From:
Sent: 28 February 2024 16:37
To: Planning ContactCentre
Subject: Application number 2023/ 93374 for 101 Old Westgate WF13 1NB - Comments
Attachments: waste @ rear 101 Old Westgate.pdf; building waste @ rear of 101, land does not belong to Applicant.pdf; 2024-02-22_title_plan_YY39802_GOV.UK (1).pdf; Official Copy of Title Plan - EDOC REGISTRATION - YY166517 (2).pdf

**RE: Planning application for 101 Old Westgate WF13 1NB
Application number 2023/ 93374**

PROPOSED SITE PLAN 1:250

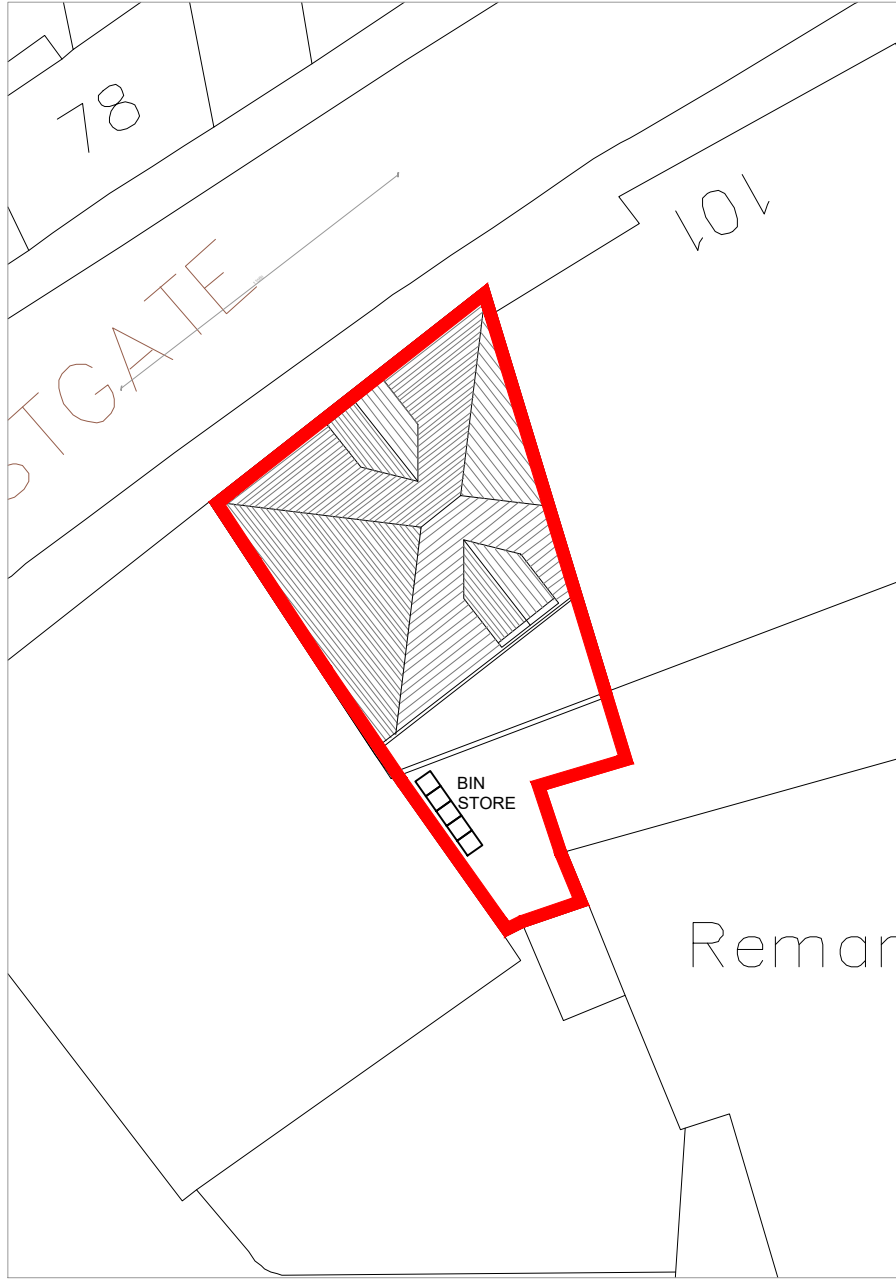
In addition the red line boundary of the garage at 101 Old Westgate provided in the application is incorrect, it incorrectly covers the back of my land. I attached the title plan deeds from the land registry, which clearly outlines the red boundary for each property.

The garage at 101 Old Westgate clearly shows it has no land at the rear of the property, yet the plan submitted at the planning application incorrectly states it does.

I own half of the private rear road and including the " bin location" of where the Applicant states he will locate his bins. The other side of the land is owned by the council. There are five existing residential bins already placed in the land owned by the council. However this side of the land has constant rubbish lying around. Any additional bins would only increase the existing problem.

what measurements can the Appliant ensure that the residential bins for his flats will not accumulate to waste lying in the streets?
